**Development Application DA09/0701.03 - amendment to
Development Consent DA09/0701 for a 256 lot residential
subdivision (Department of Planning Application MP09_0166
MOD 3) at Lot 1 DP 169490 & Lot 1 DP 175235 & Lot 1 DP
304649 & Lot 1 DP 781687 & Lot 1 DP 781697 & Lot 40 DP
254416 & Lot 43 DP 254416; No. 37 Fraser Drive TERRANORA;
Lot 2 DP 778727; Parkes Lane TERRANORA**

I refer to your email of 6 August 2018 in which you notify Tweed Shire Council of the Proponents' Response to Submissions regarding the subject Modification.

The Response has been reviewed by Council Officers and the following comments are provided for your consideration during assessment of the application.

NEWLAND DEVELOPERS PTY LTD	
TERRANORA PRECINCT 1 CENTRAL OPEN DRAIN SWALE PLAN	
09-374 21.09-2017	SK3618 REVISION E

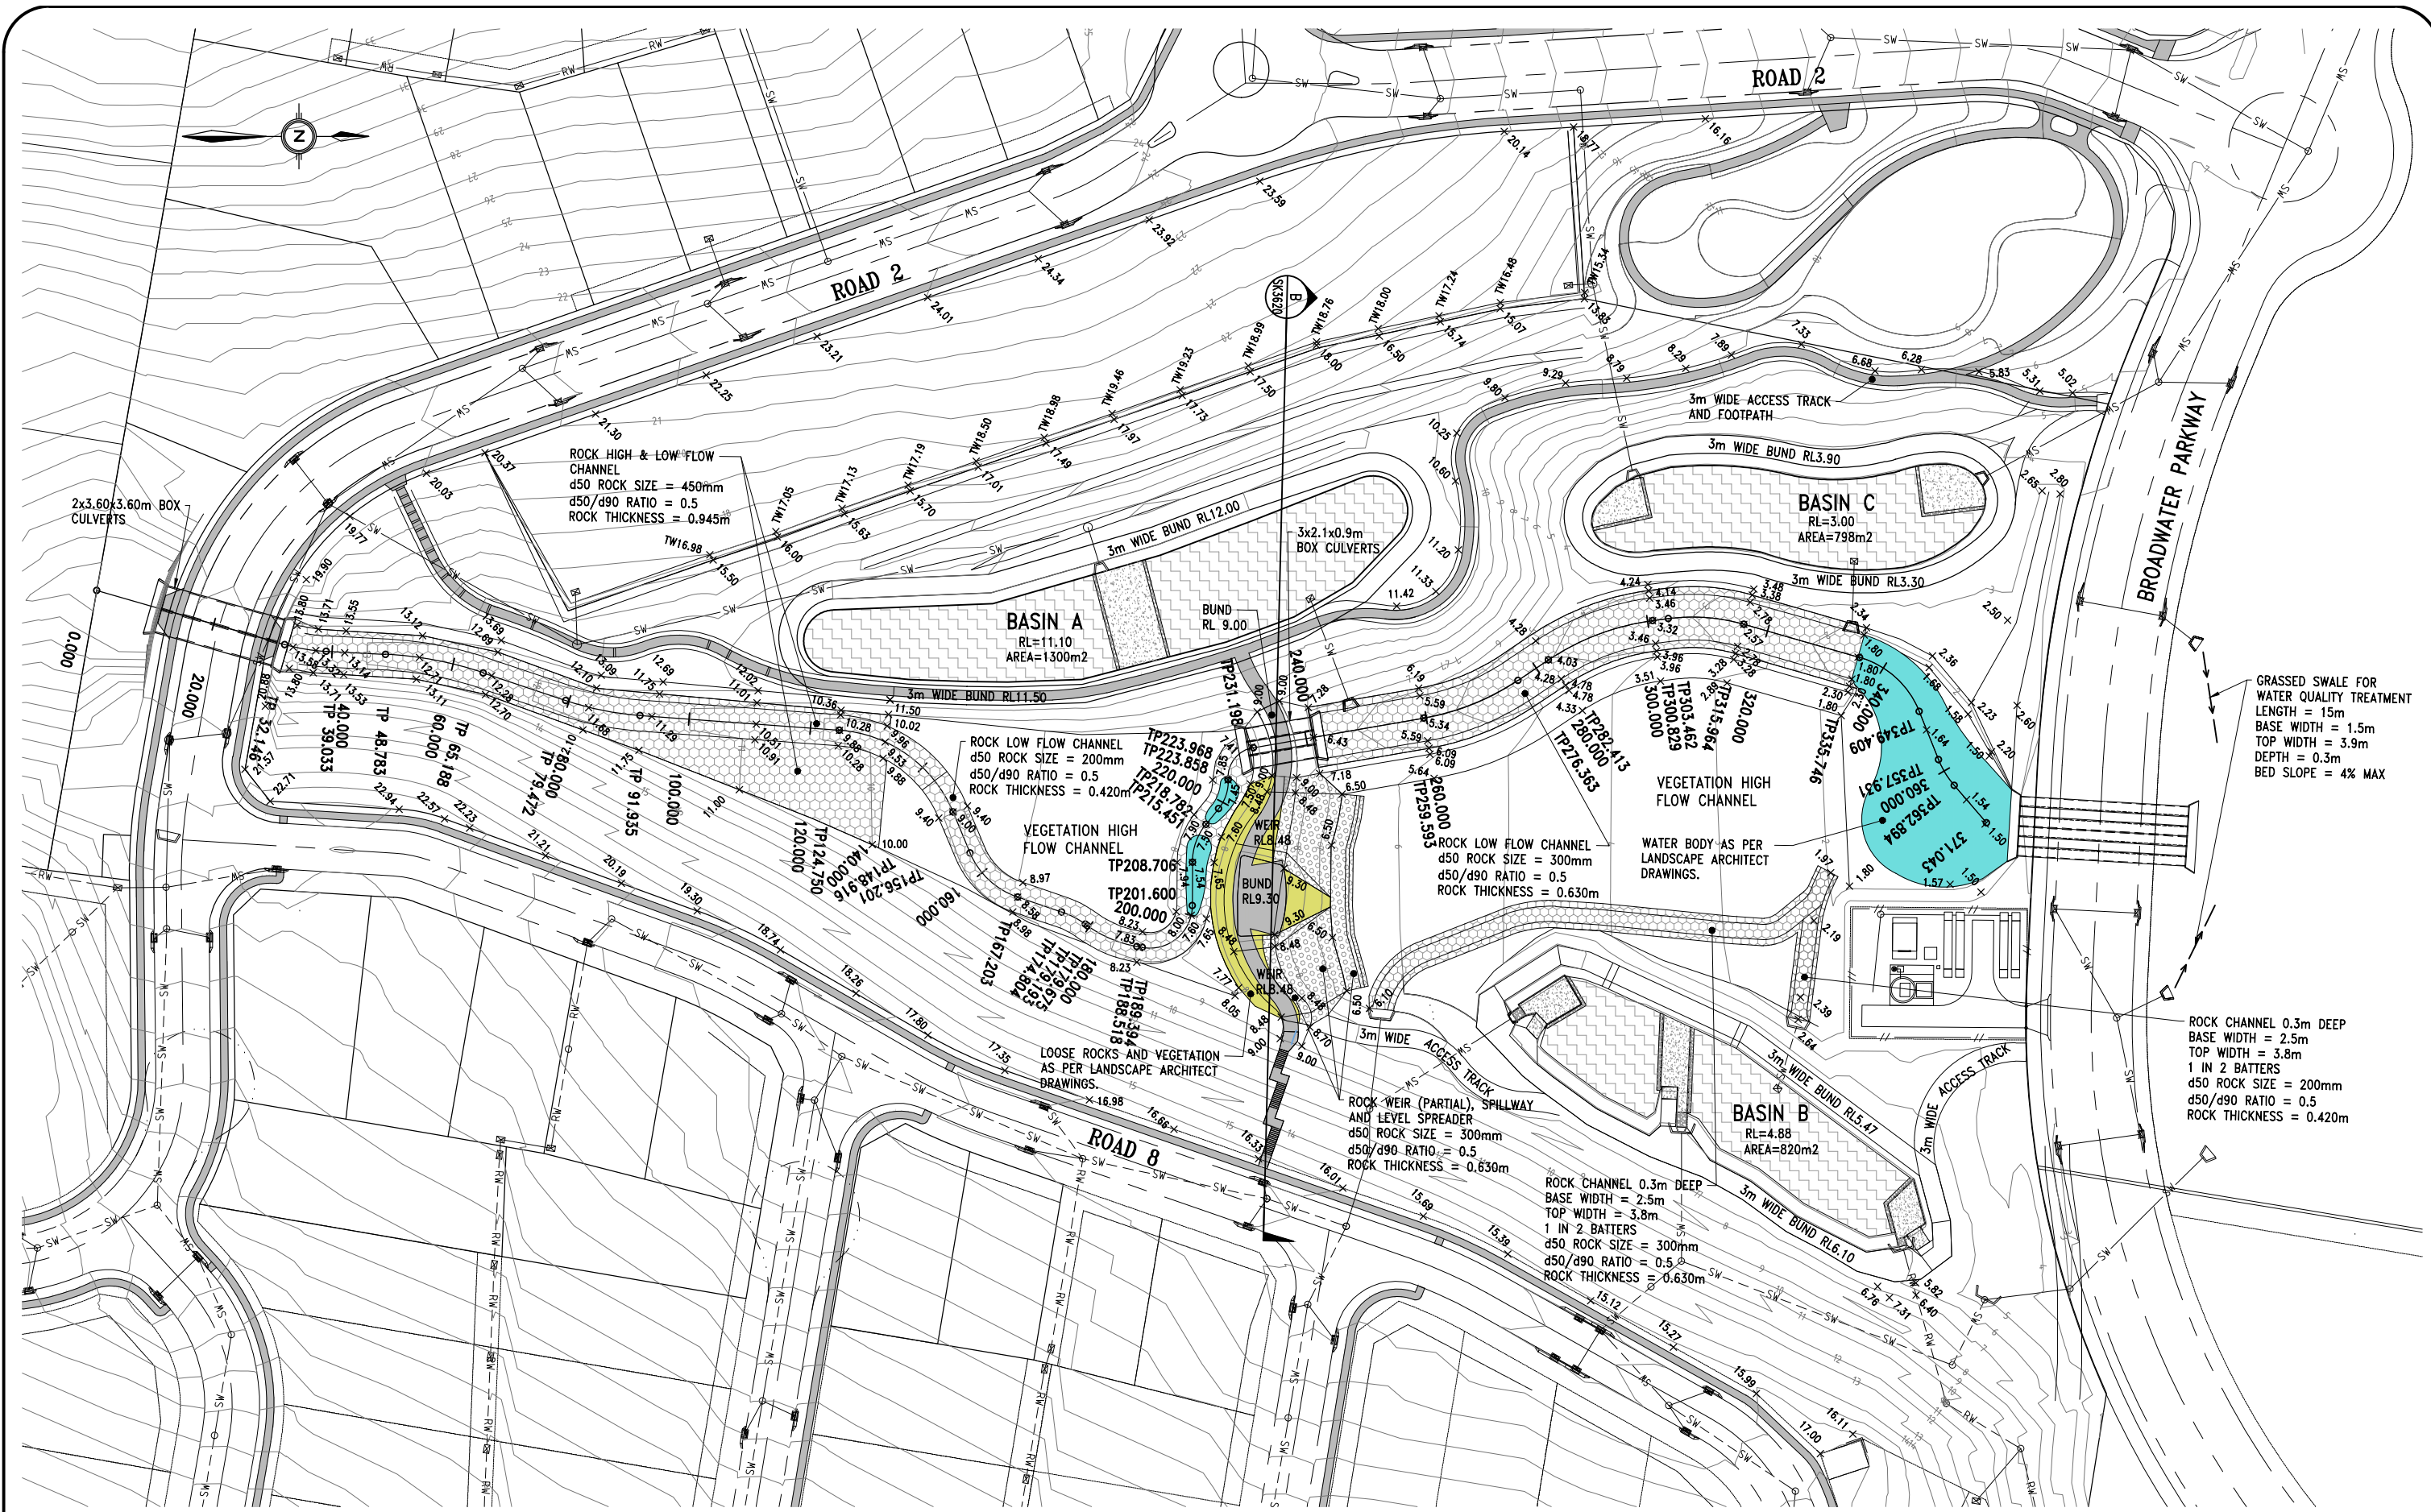
Further on this point, the concrete footpath that links the main central path with the maintenance track for Basin B is to be deleted: dwg SK3618/2 refers.

NEWLAND DEVELOPERS PTY LTD	09-374 16-11-2017
TERRANORA PRECINCT 1 RETAINING WALL LAYOUT	SK 3617 REVISION F

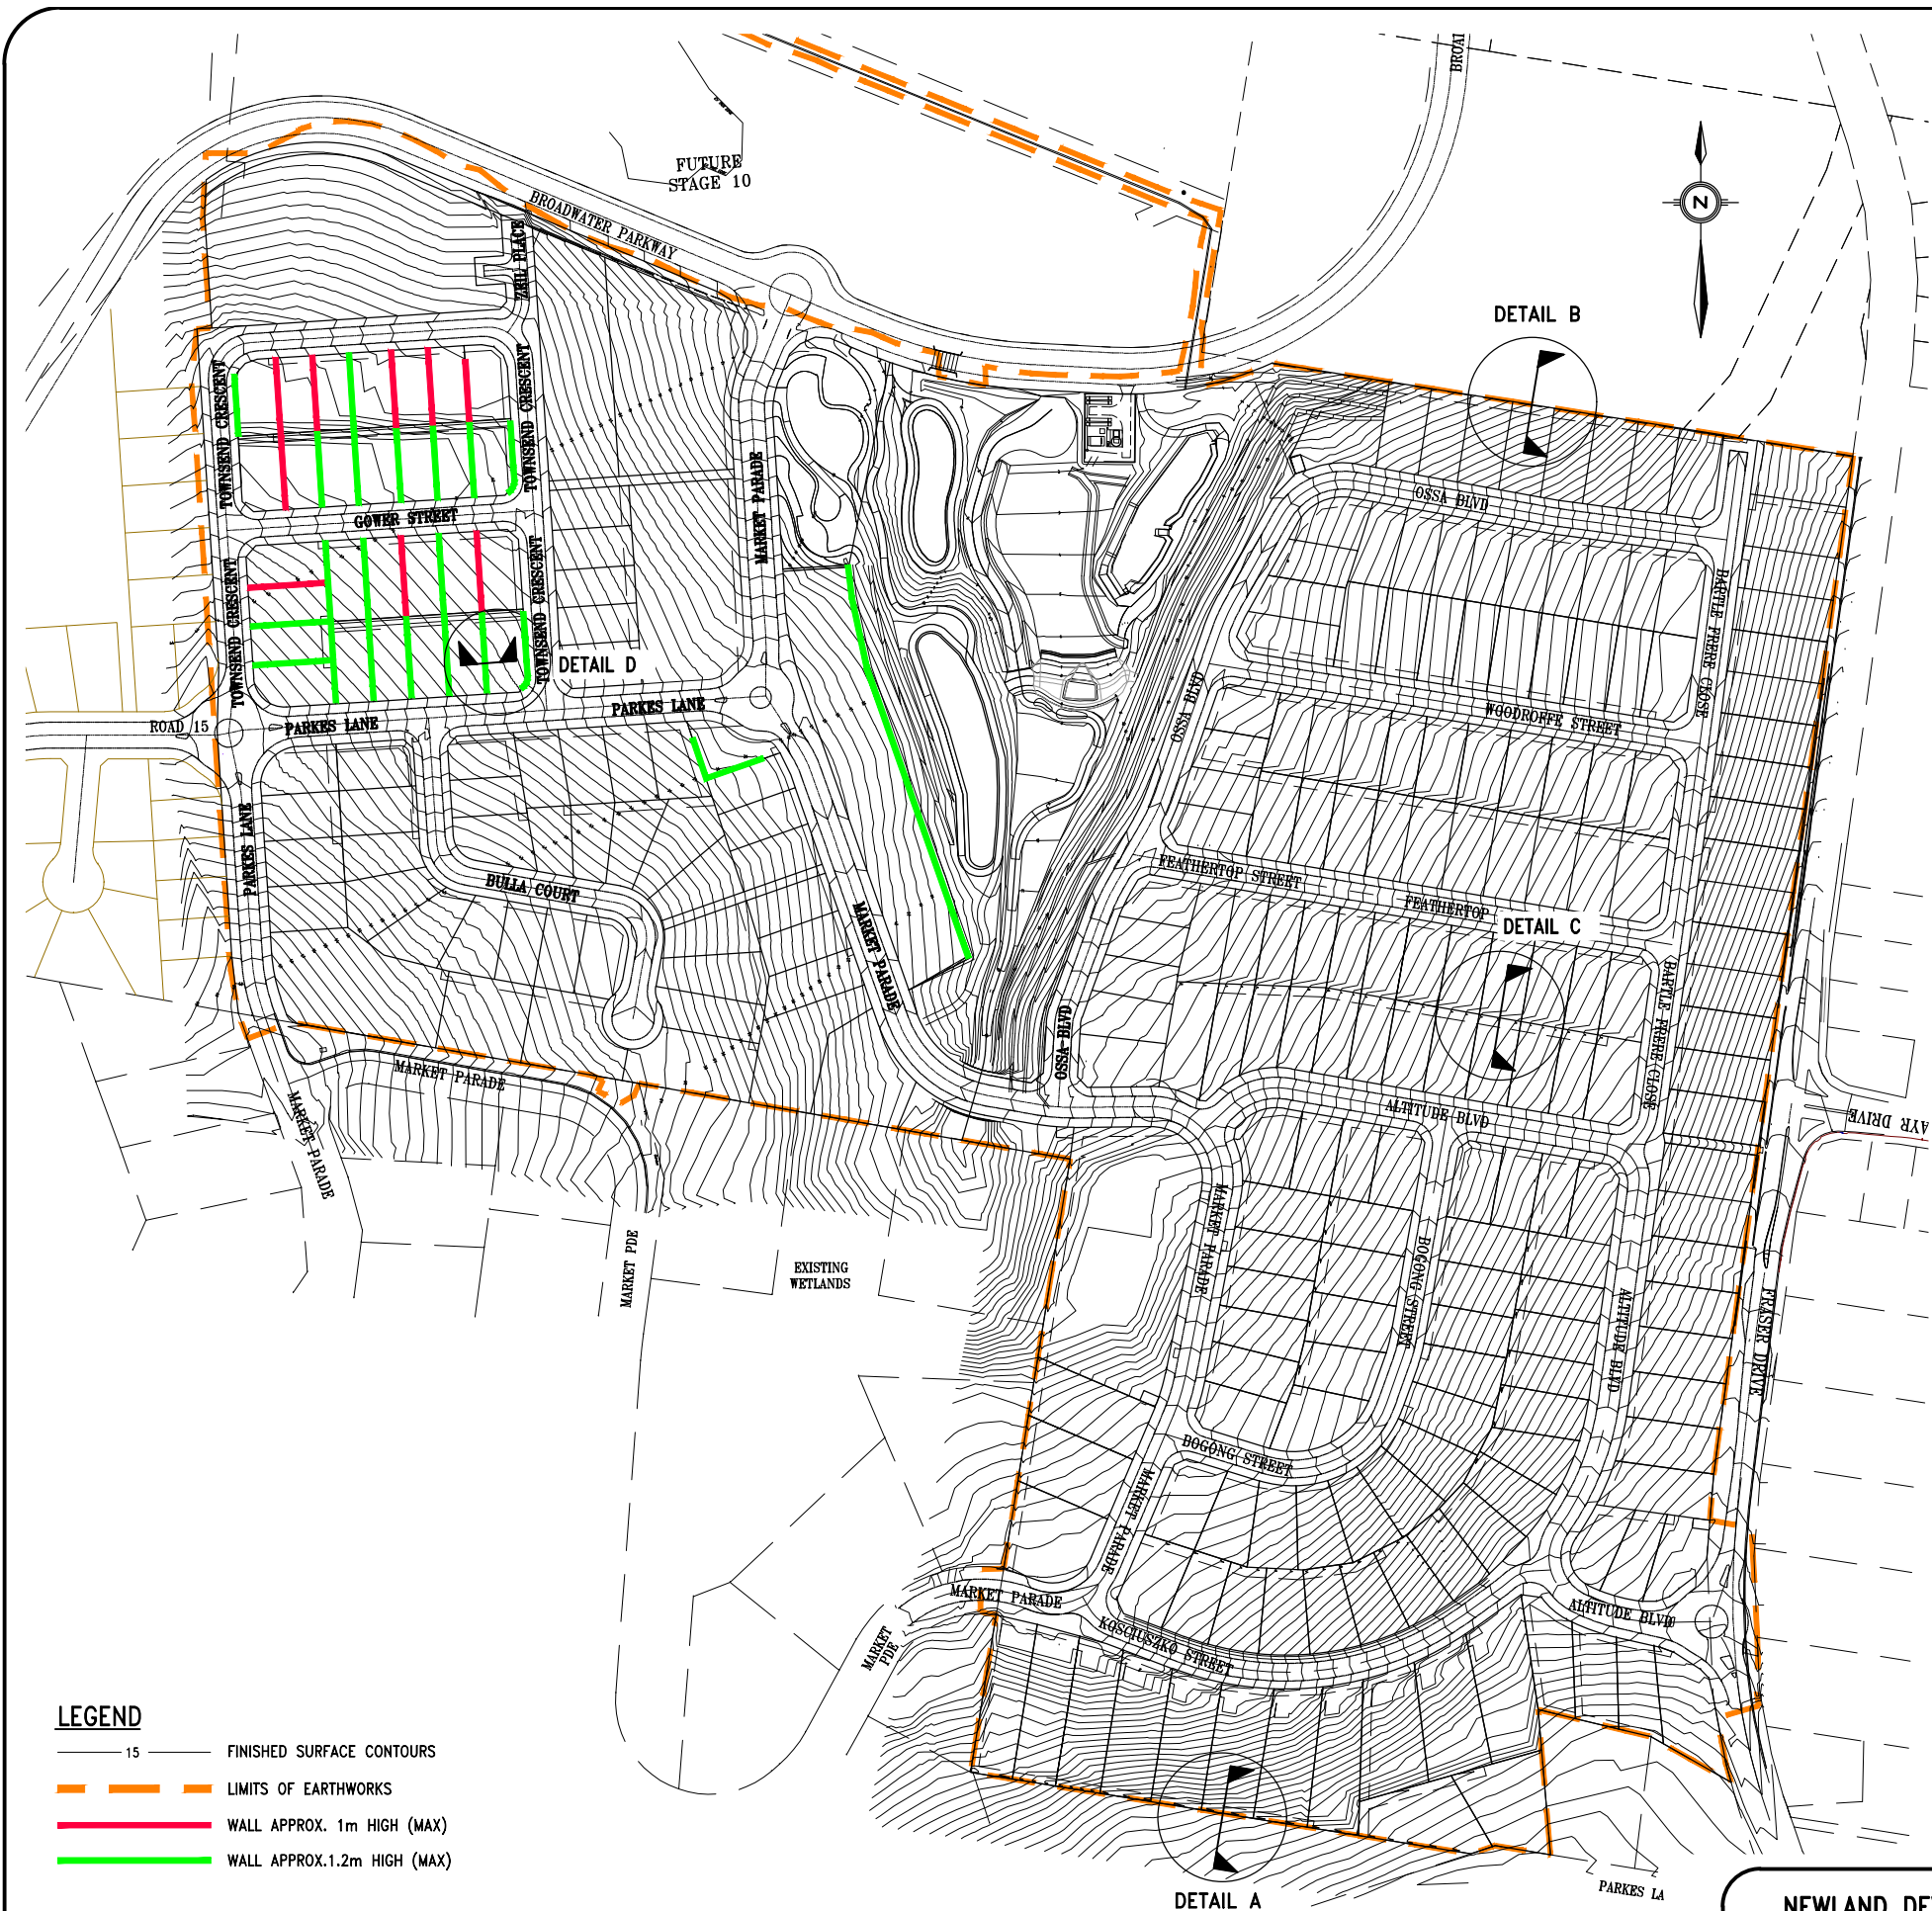
- Amended plans SK3591 – 3594, and SK3609 – 3611 are still referenced under the second 'Drawing No.' item in the 'Engineering Drawings' table. Appropriate amendment is required to avoid referencing two different versions of any approved plan.
- Amended plan SK3626 still retains its original reference in the 'Engineering Drawings' table. Deletion of the original plan reference is required to avoid nomination of two different versions of the same plan.
- SK3617: the inclusion of this plan is not supported.

This plan depicts retaining walls being constructed along property boundaries, which conflicts with the requirements of Condition B18.

It is further noted that this plan was not part of the original approval, but was however alternatively referenced in Condition A10 to disapprove retaining walls in the eastern portion of the development site. In the absence of any mention of lots in the western portion of the development site within Condition A10 to alternatively allow retaining walls along boundaries, the terms of Condition B18 are considered to take priority.
